**OXFORDSHIRE COUNTY COUNCIL'S RESPONSE TO CONSULTATION ON THE  
FOLLOWING DEVELOPMENT PROPOSAL**

**Application no:** 14/01738/OUT

**Proposal:** Outline – development of 48 houses, access, open space and landscaping.

**Location:** Land North of Railway House Station Road, Hook Norton

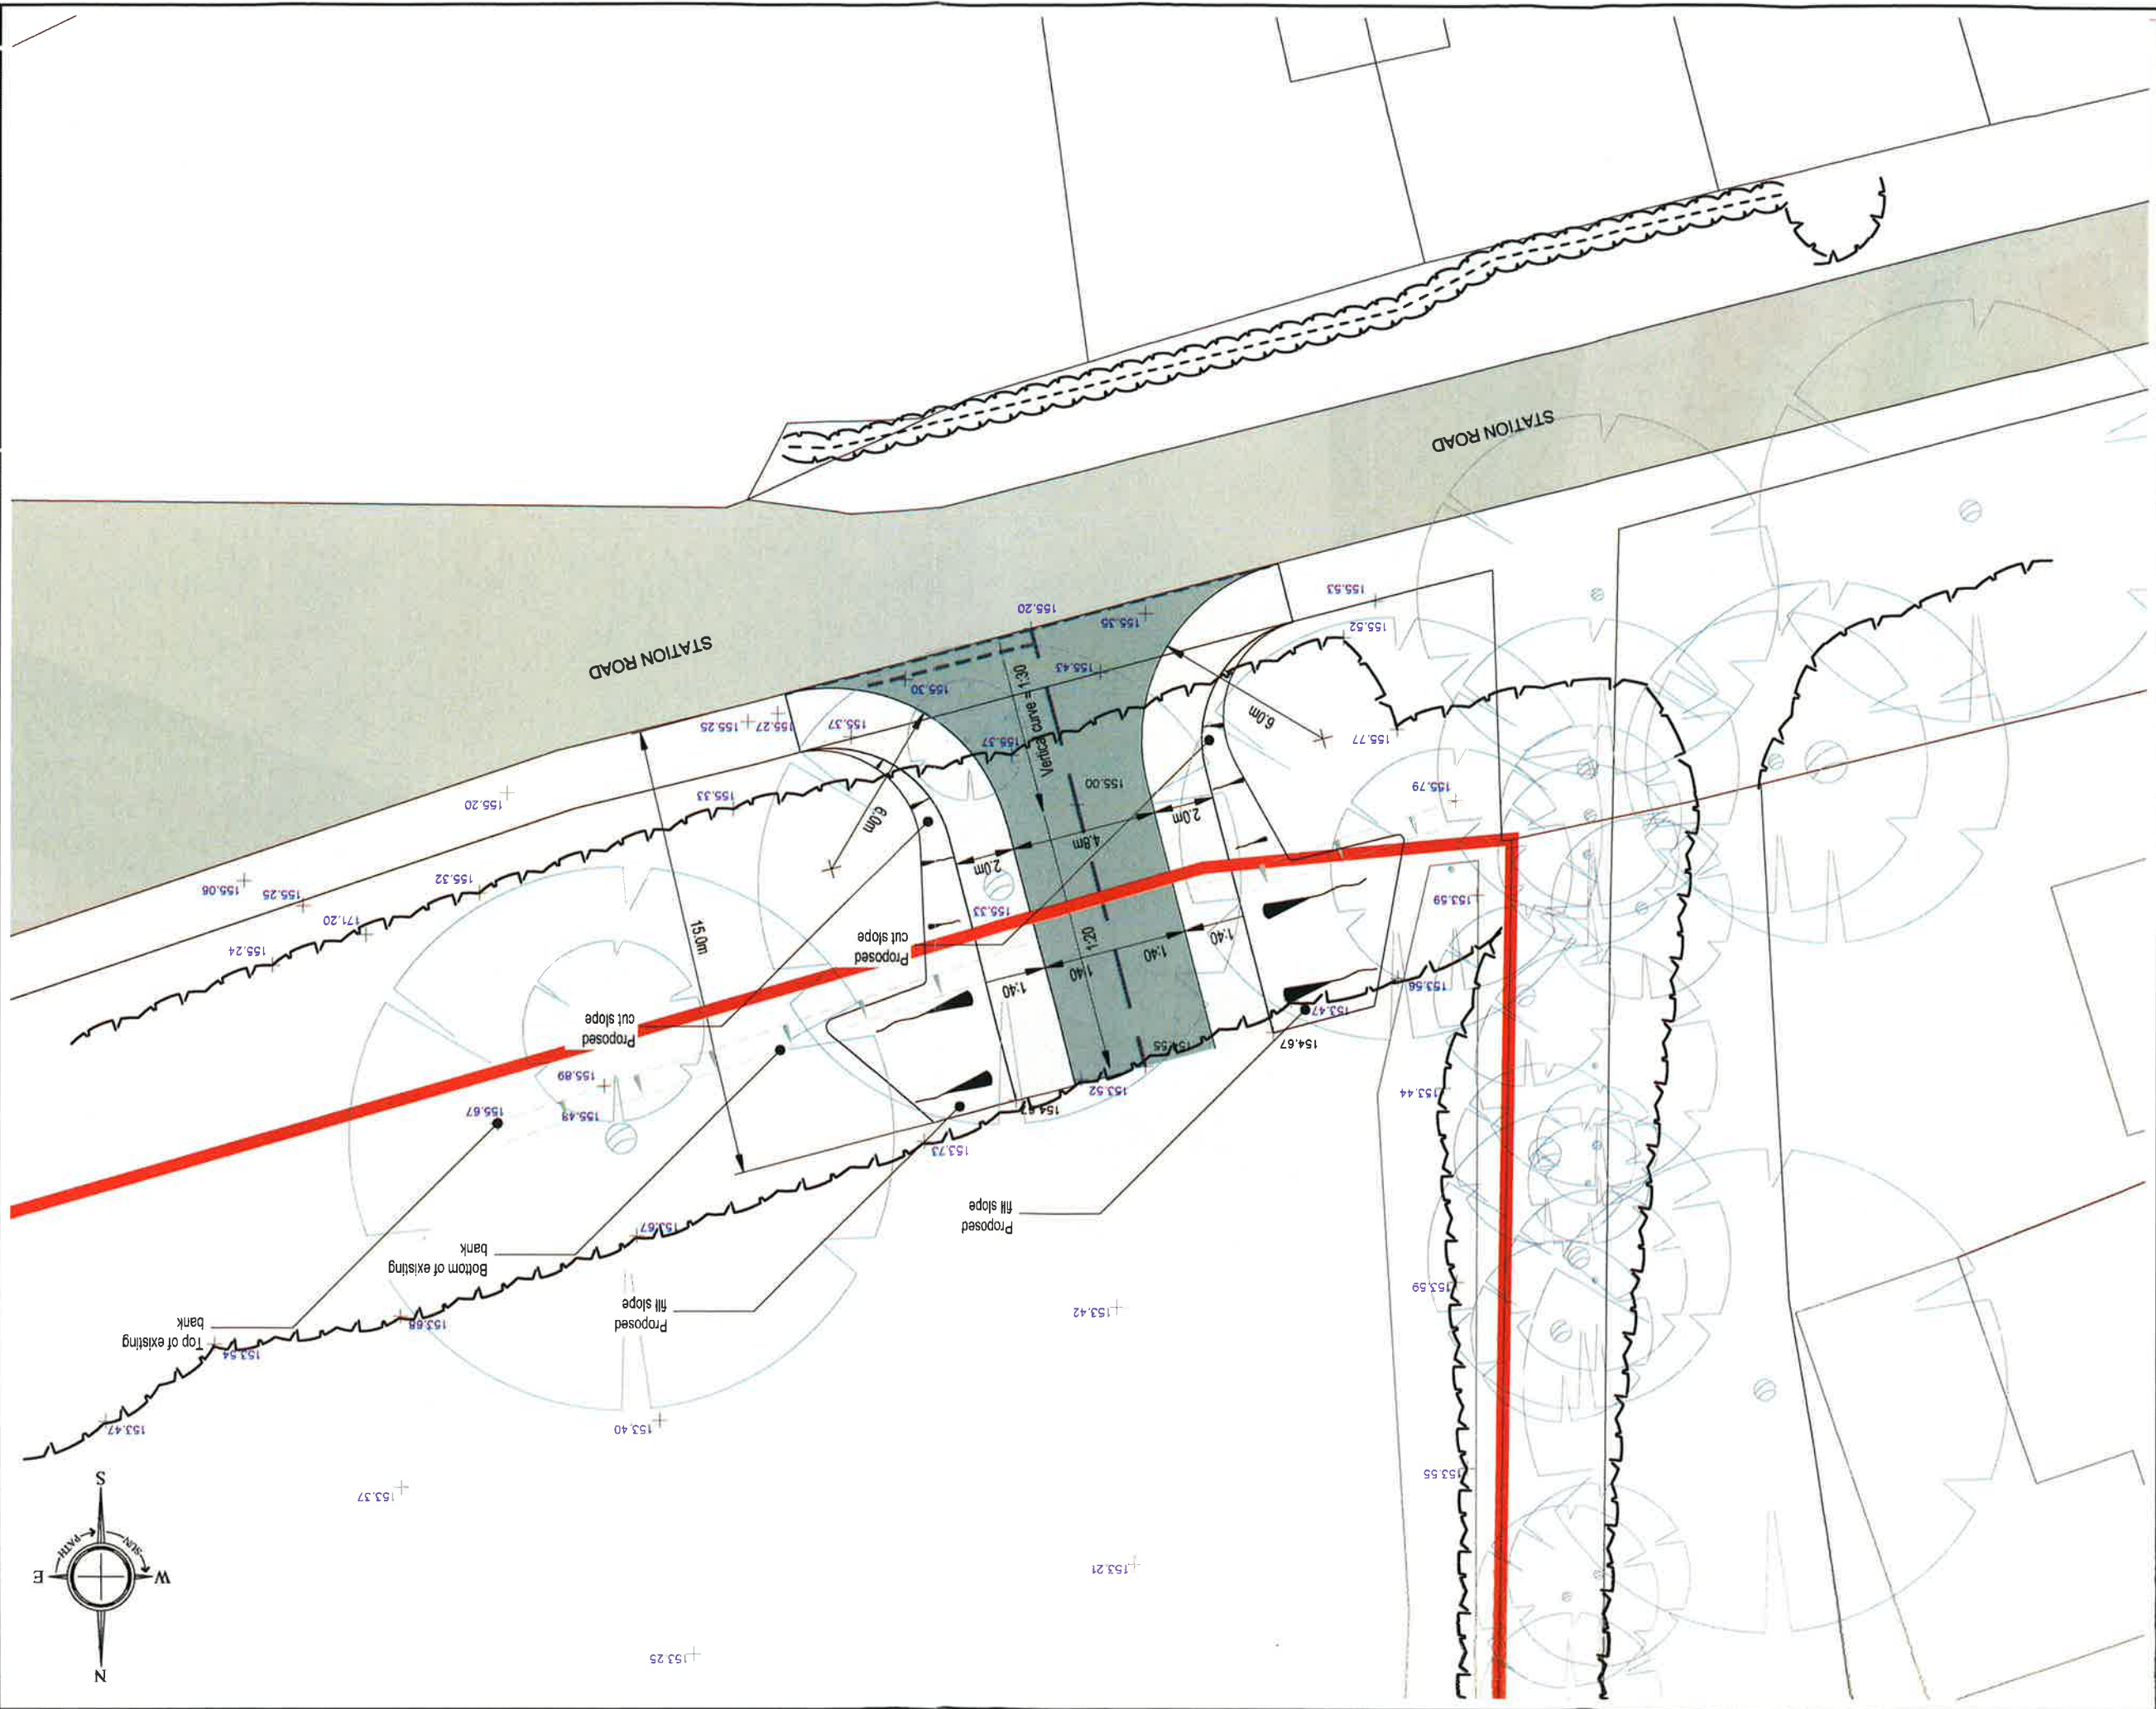
The proposed site access is shown on submitted plan 14045-PO1; however this contradicts the visibility splays quoted in the Transport Assessment. This matter must be resolved and will require the submission of a detailed plan of access. The layout of the site is not to be determined at this stage; however illustrative plans appear acceptable in principle. A full drainage strategy, layout plans and drainage calculations will be required and approved by the Lead Flood Authority (Oxfordshire County Council) prior to the commencement of any development.

Prior to development a detailed plan of the vehicular access shall be submitted to and approved by the Local Planning Authority and shall be strictly in accordance with the approved plan.
